**DELEGATED DECISION FOR APPLICATION FOR CERTIFICATE OF
LAWFUL DEVELOPMENT**

Reference no.: 2025/CL/92134/W

Site: 152, Woodside Road, Beaumont Park,
Huddersfield, HD4 5JF

Description: Certificate of lawfulness for proposed garage
conversion and erection of rear canopy with associated external alterations

PHASE	SCALE	SHEET NO.	PROJ.NO.
Planning Application	1:100 @ A3	AR-03	C25032

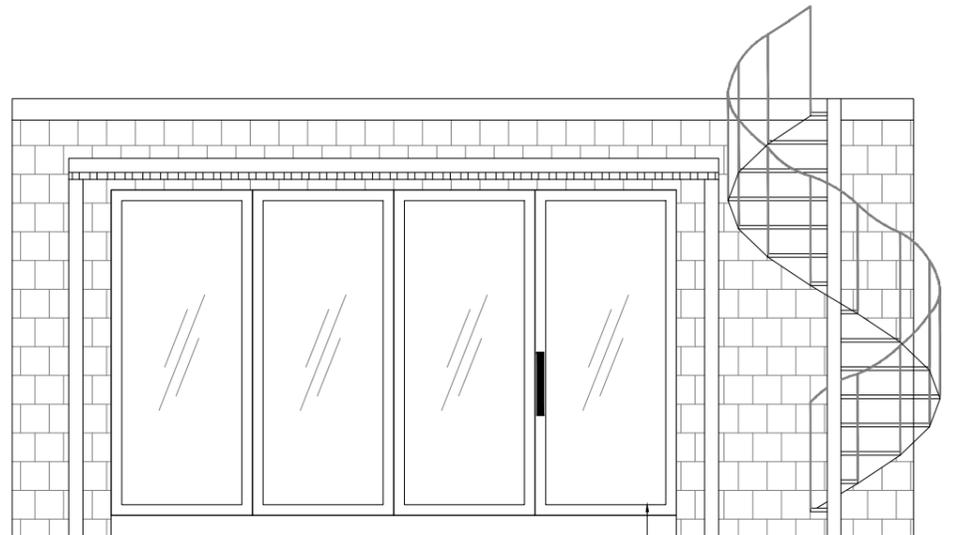
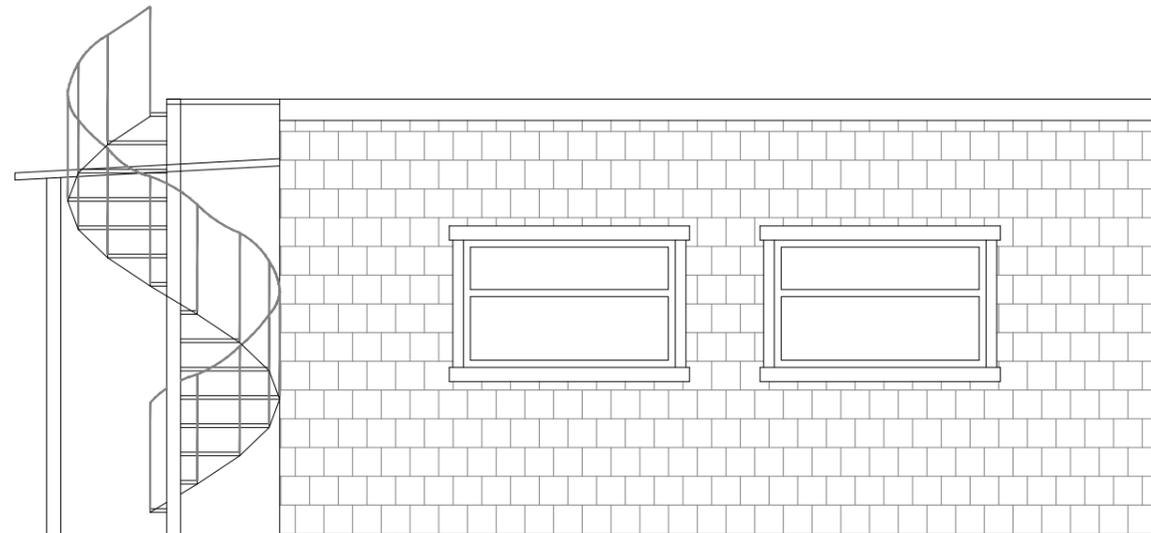
It is noted that the elevation plans provided with the application are indicated to be at a scale of 1:100 which appears to be incorrect. However, when scaled at 1:50 the measurements accord with the annotated width of the sliding doors and measurements of the external walls of the building taken from the Council’s mapping systems.

Comment: *The building is proposed to be externally altered with changes to doors and fenestration, erection of canopy at 2.6 metres about ground level and spiral staircase at 3.75 metres about ground level. As the resulting building as altered is within 2 metres of the boundary of the curtilage with alterations in excess of 2.5 metres above ground level, the proposed development exceeds the limitations of sub-paragraph E.1(e).*

Comment: *The height of the eaves of the building as altered exceeds more than 2.5 metres about ground level.*

Comment: *While the works would include a proposed spiral staircase which would provide access to the roof of the building the application form states that this would be to provide 'occasional maintenance access'.*

The submitted application form states that the garage conversion would create a home office for the private, incidental use of the homeowner and would be used solely for desk-based work, with no client visits and no regular staff presence and would replace a study used within the main house. However, the internal arrangements as shown on the submitted floor plans indicate a desk arrangement consisting of 4 desks with unspecified seating arrangements

which appears to go beyond a space typically required for home working. In the event the proposed alterations did accord with the limitations further clarification would have been required for consideration.
